26 November 2014

Letter of support - Lismore Base Hospital – Stage 3B

2 NORTH - 3B2 1:200
SCALE 1:200

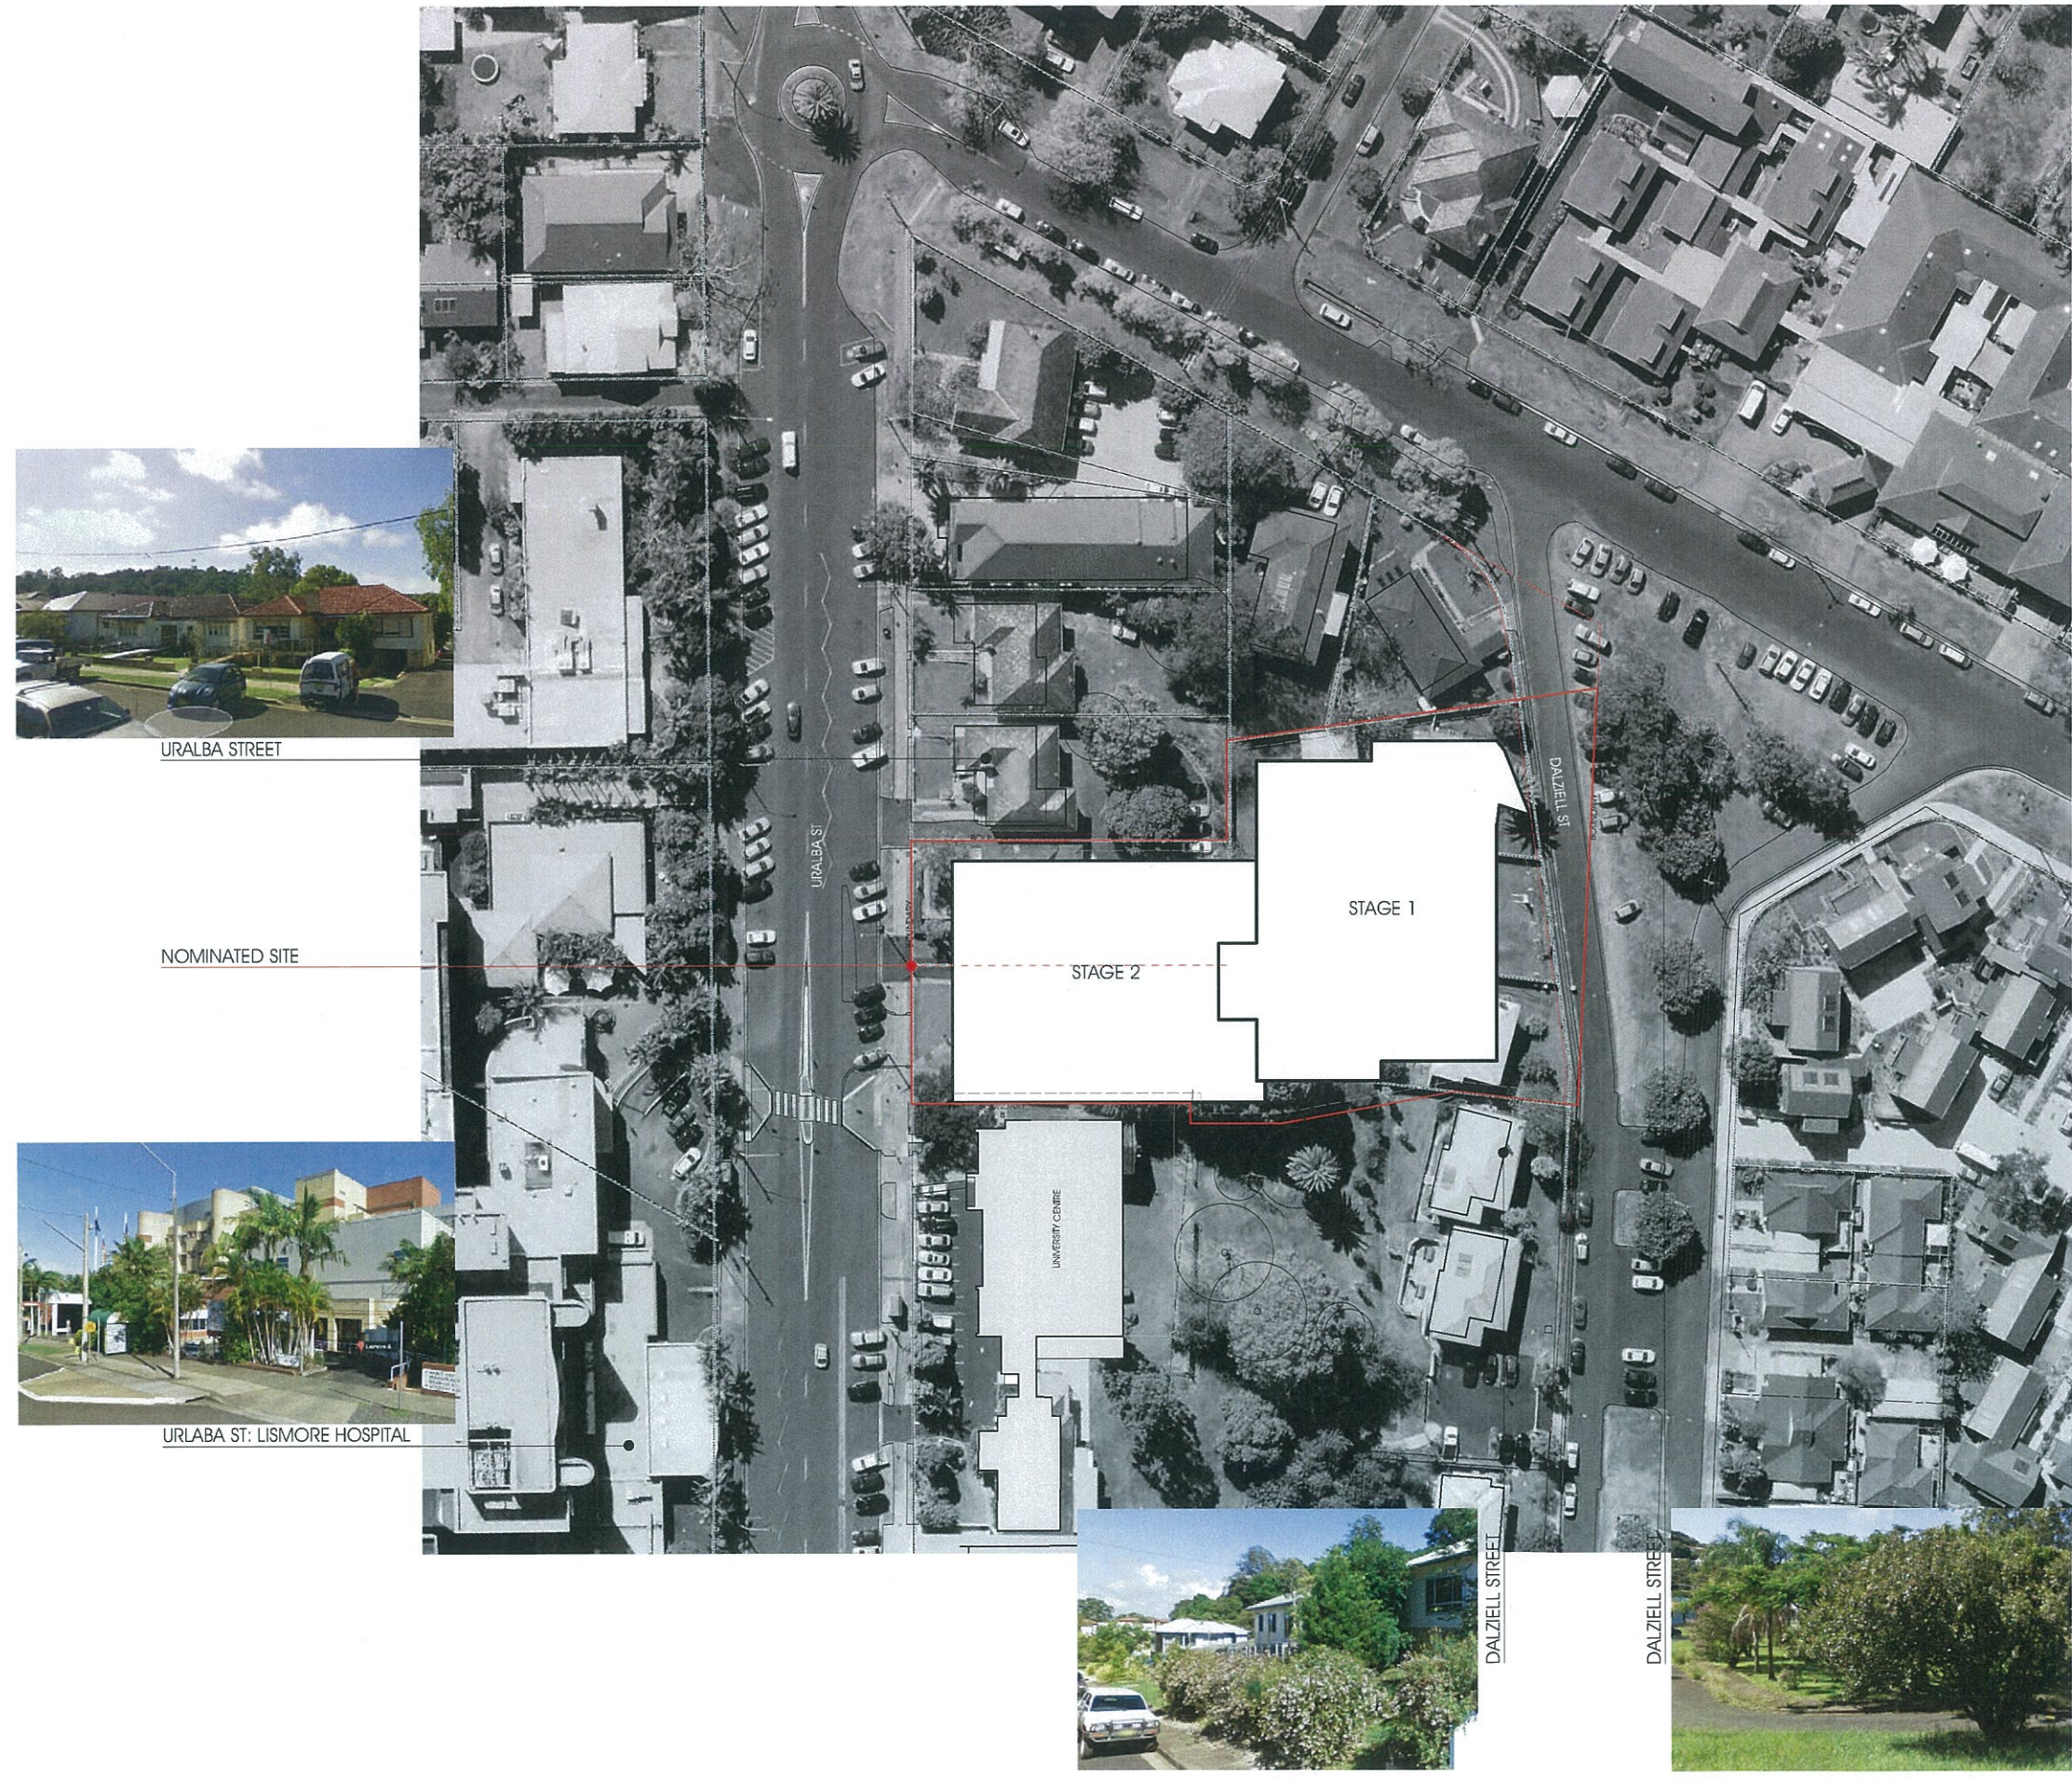
The second part of the proposed 3B stage is a five level building that has been integrated into both the natural topography and the current Stage 3A works. It is the lower level of this second part of the works that will contain the loading dock for the hospital. This area has direct street access to Little Uralba Street and is across the road from three lots which are owned by the Lismore Base Hospital.

Little Uralba Street is currently a narrow one way road servicing the Base Hospital and four other residences. For your proposed vehicular and truck manoeuvring areas to function well it will be necessary for you to integrate your open space areas on the eastern side of Little Uralba Street with your loading areas on the west. This integration will require the closing of part of Little Uralba Street. Council supports this proposal as it ensures the level of service on Uralba Street remains high, provided the remaining residents in Little Uralba Street and the public generally are provided with serviceable carriageways, pedestrian areas and vehicular turning areas.

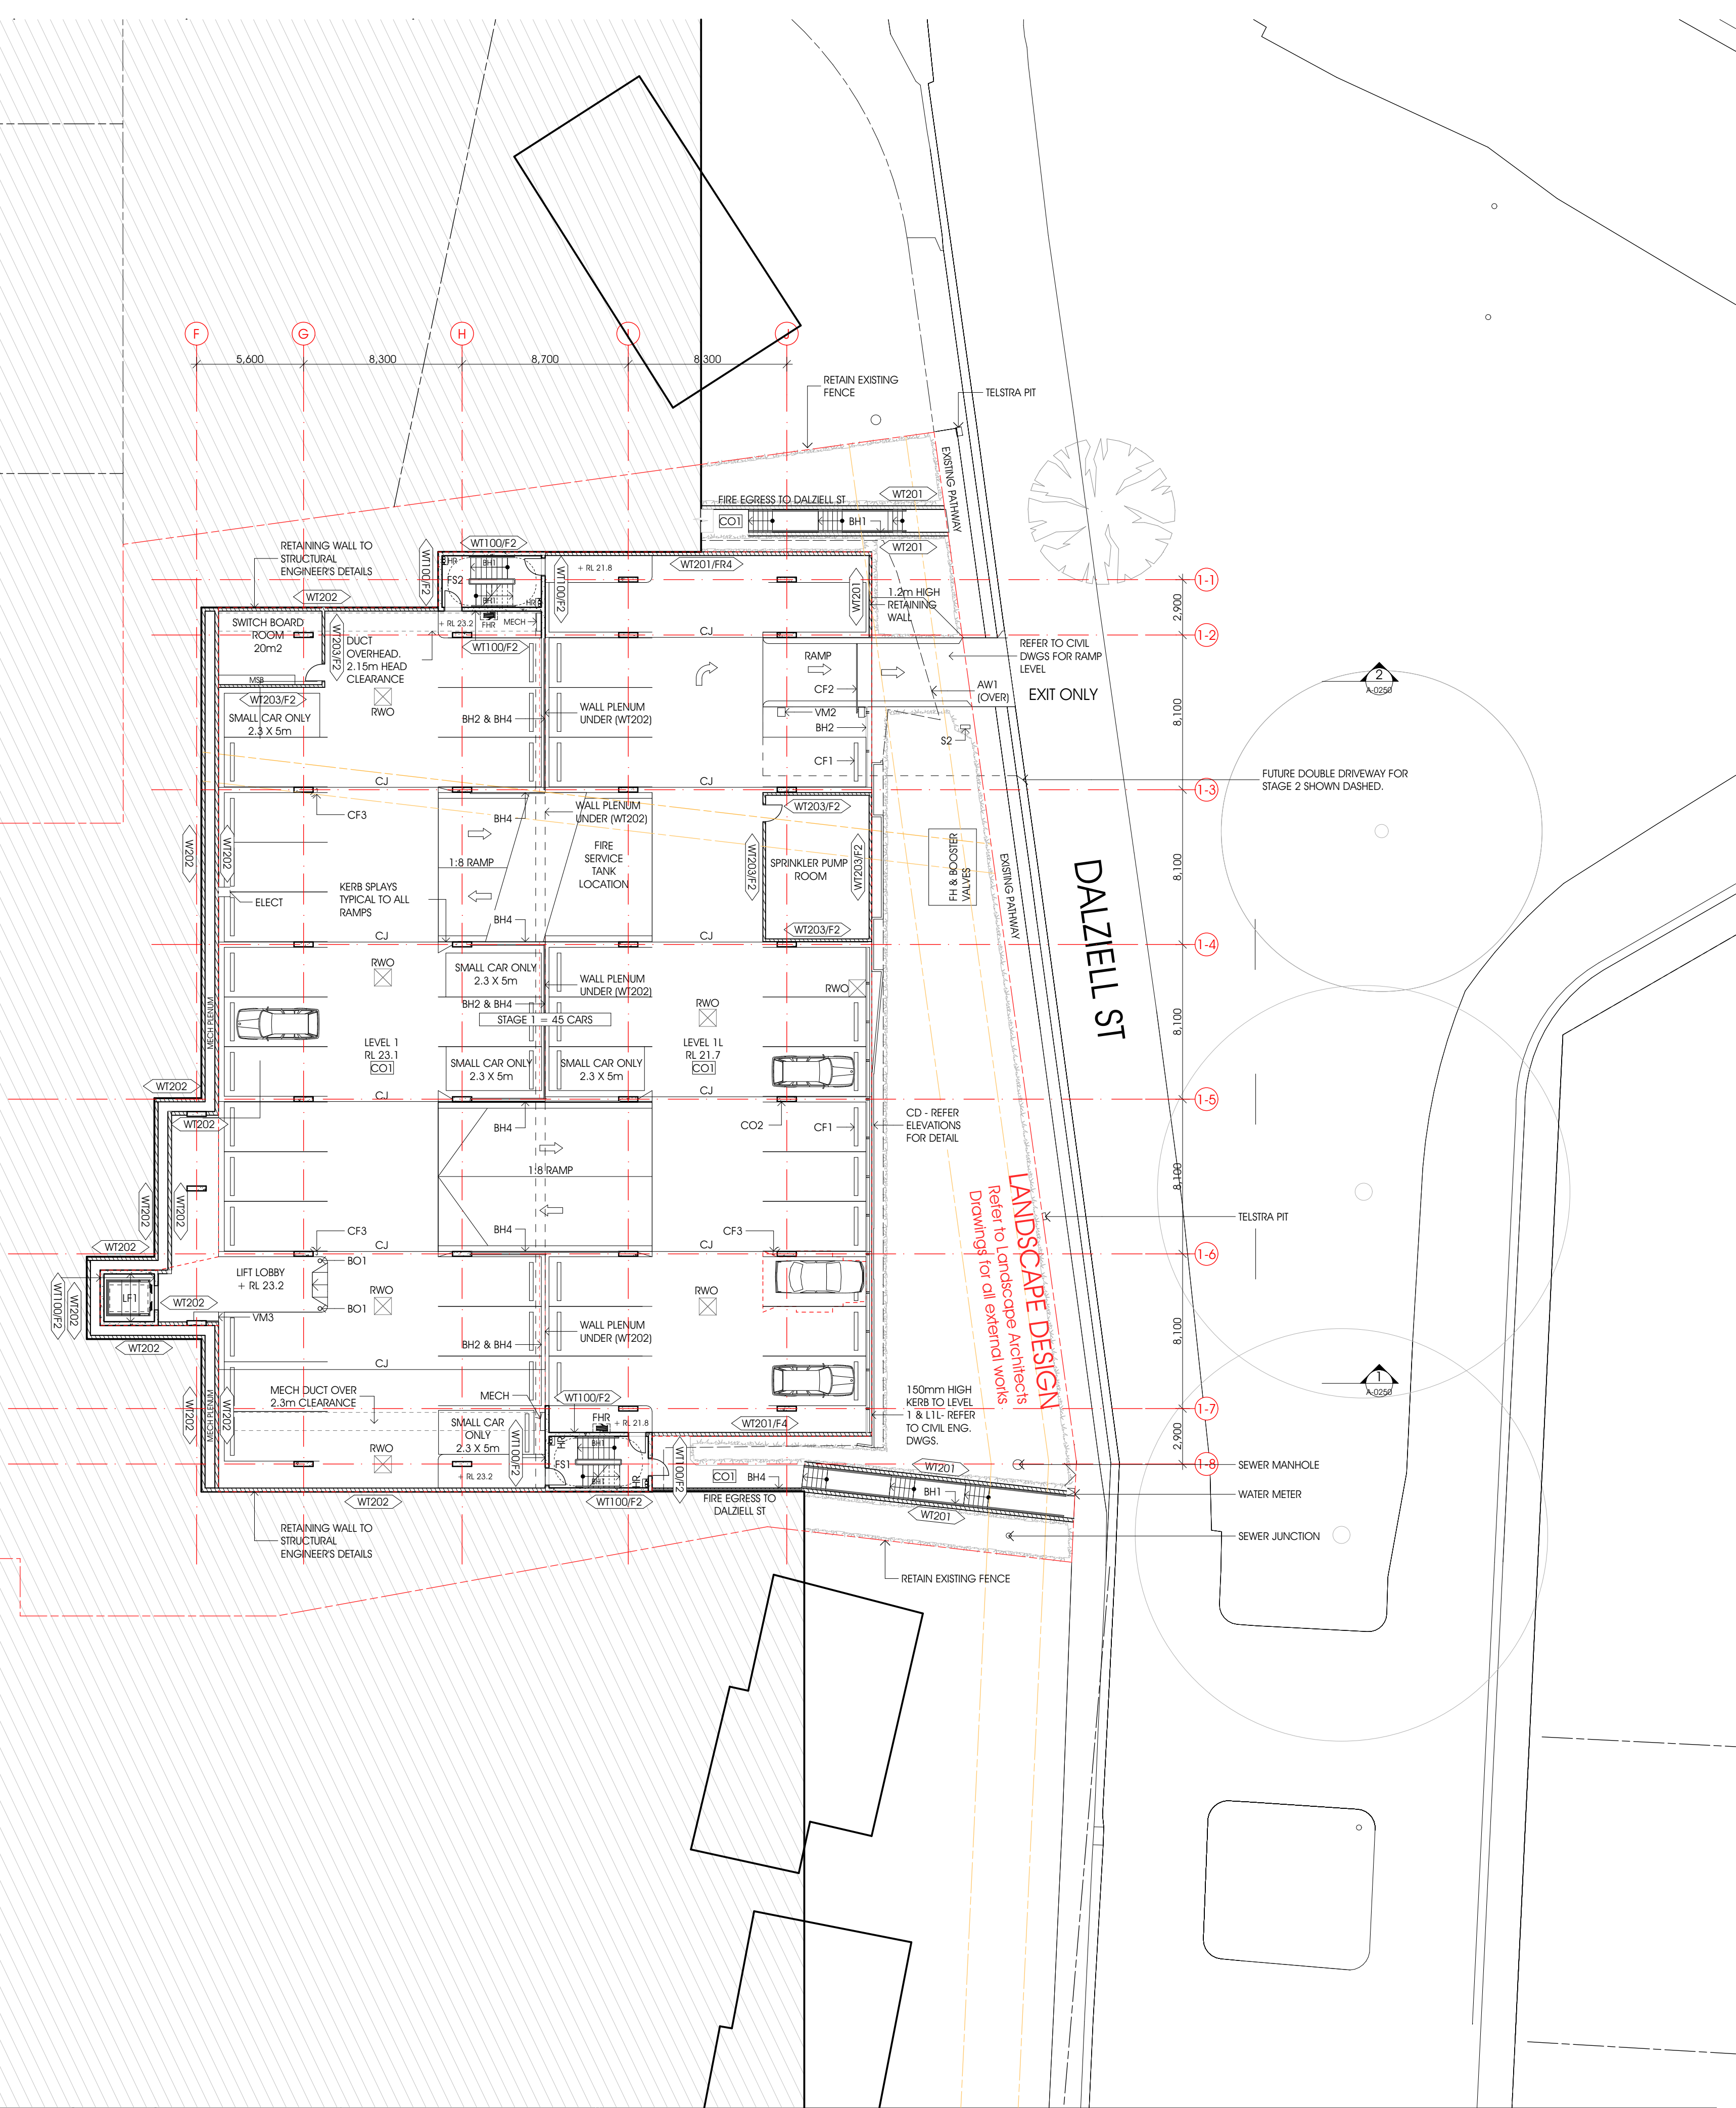
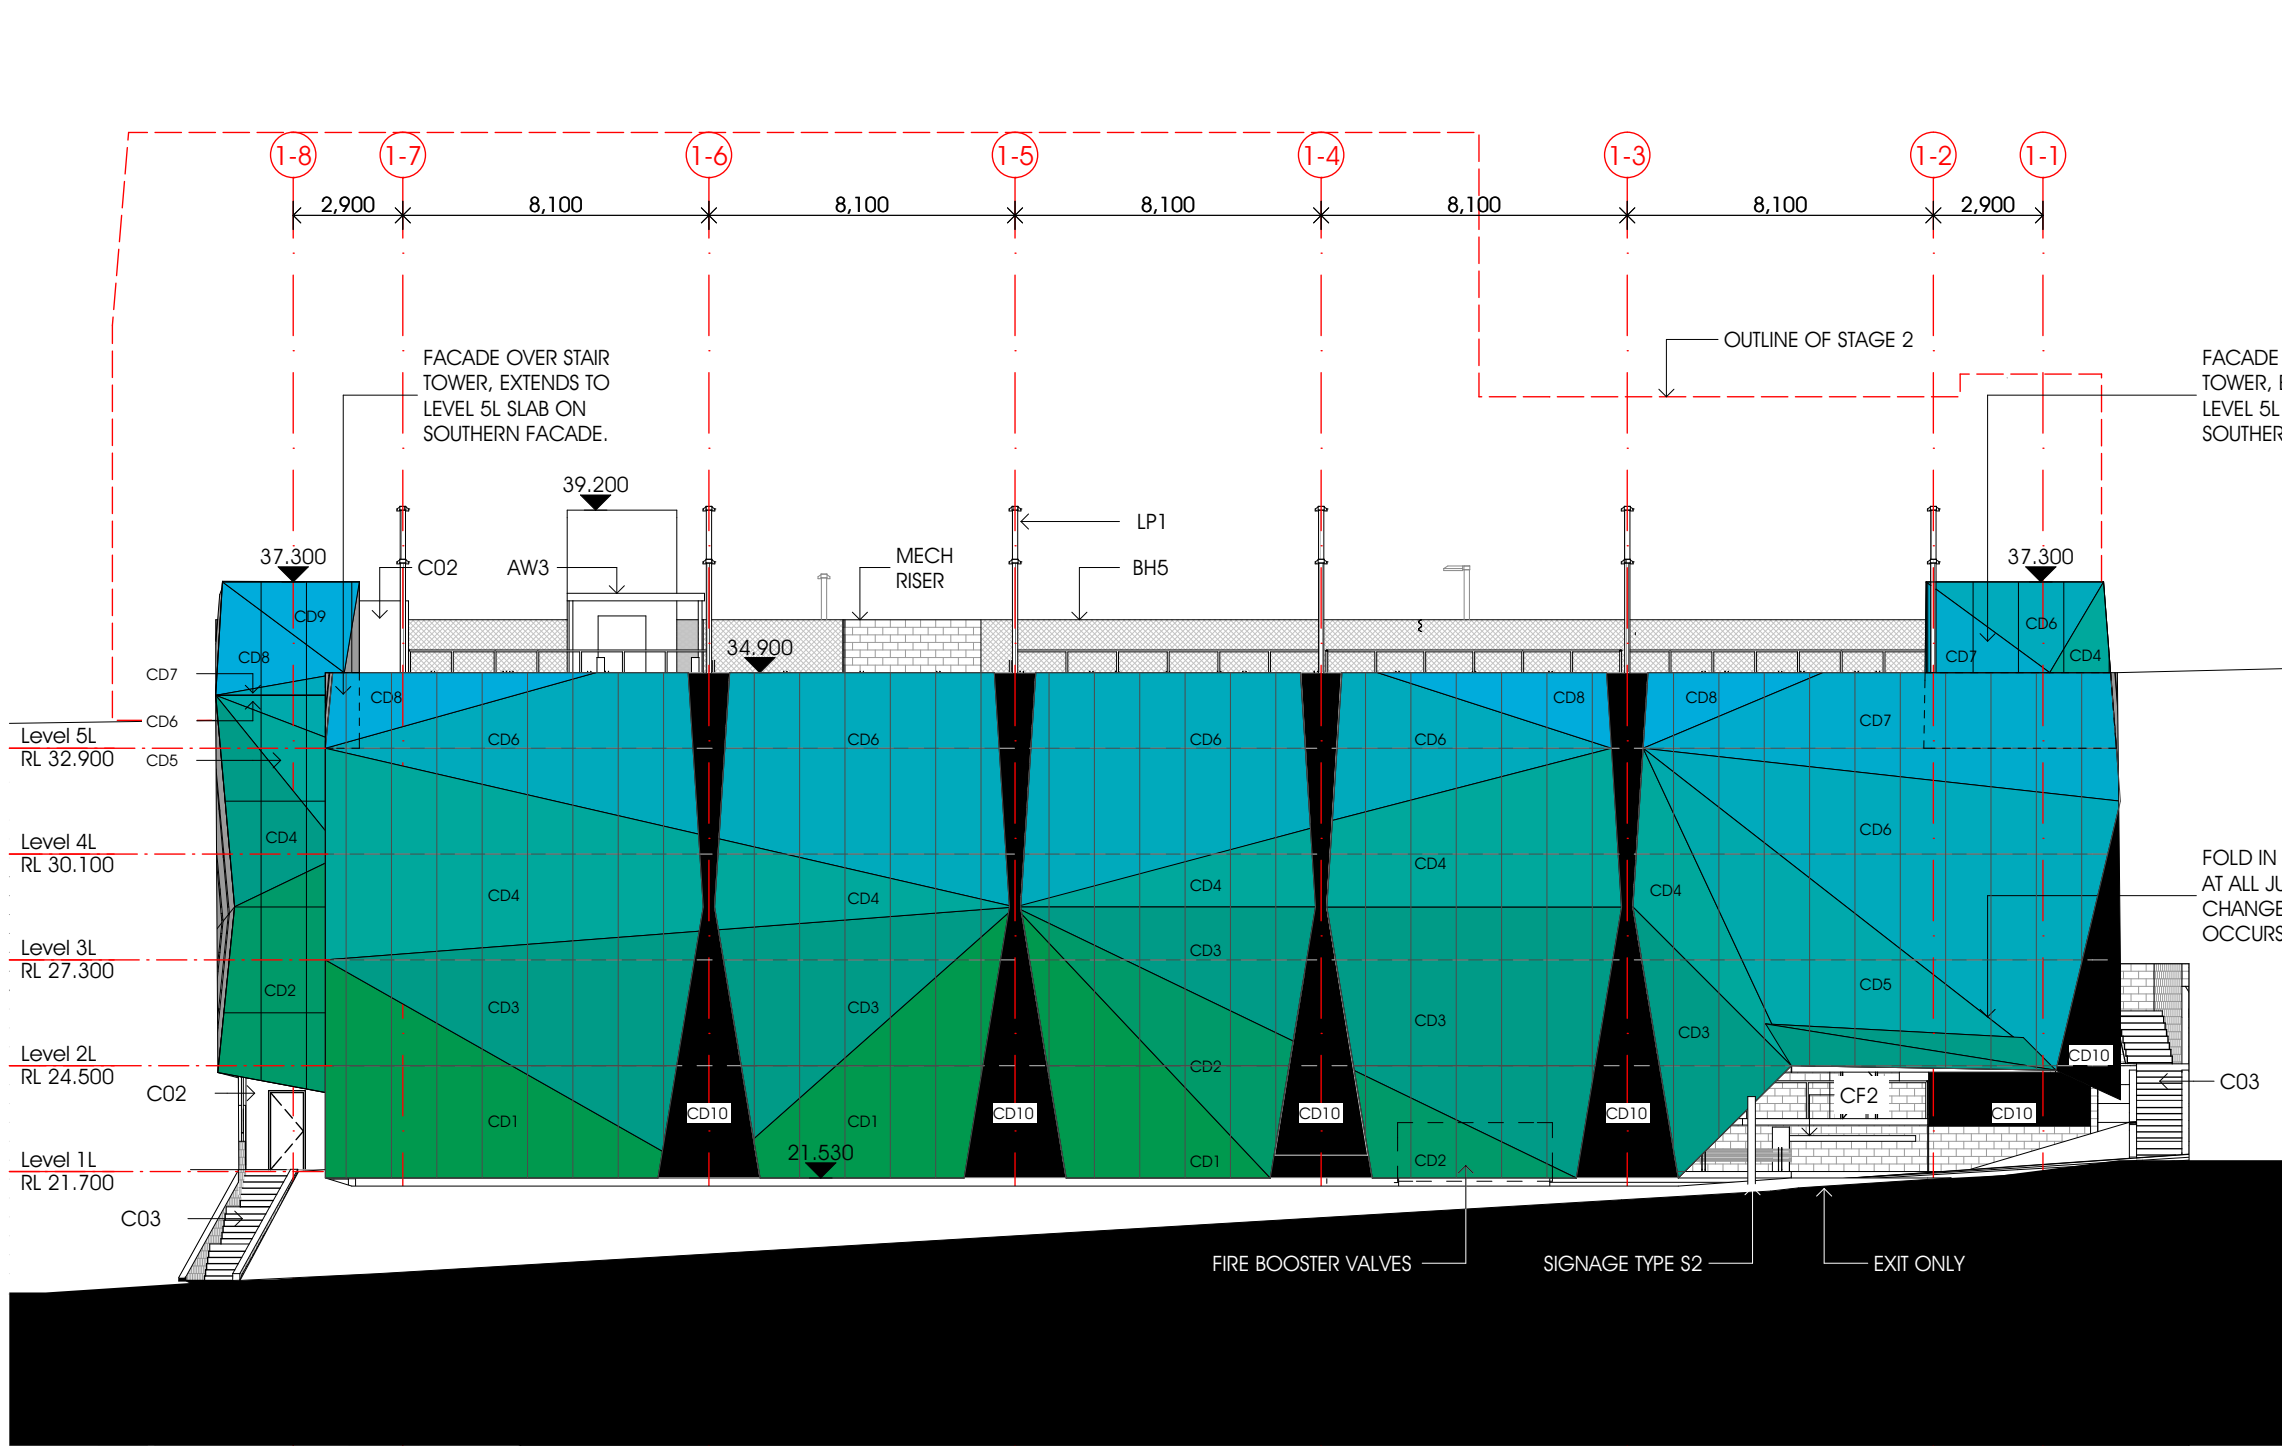
Council congratulates you on the 500 car parking station that you have proposed between Uralba Street and Dalziell Street. This facility will greatly improve the amenity of the residents who live in proximity to the Hospital and will serve well both the staff and visitors to the hospital. The cladding you propose for this car park will greatly assist in integrating this building into what is essentially a residential area and alleviate previous concerns about the possible visual impact of such a significant and important infrastructure facility.
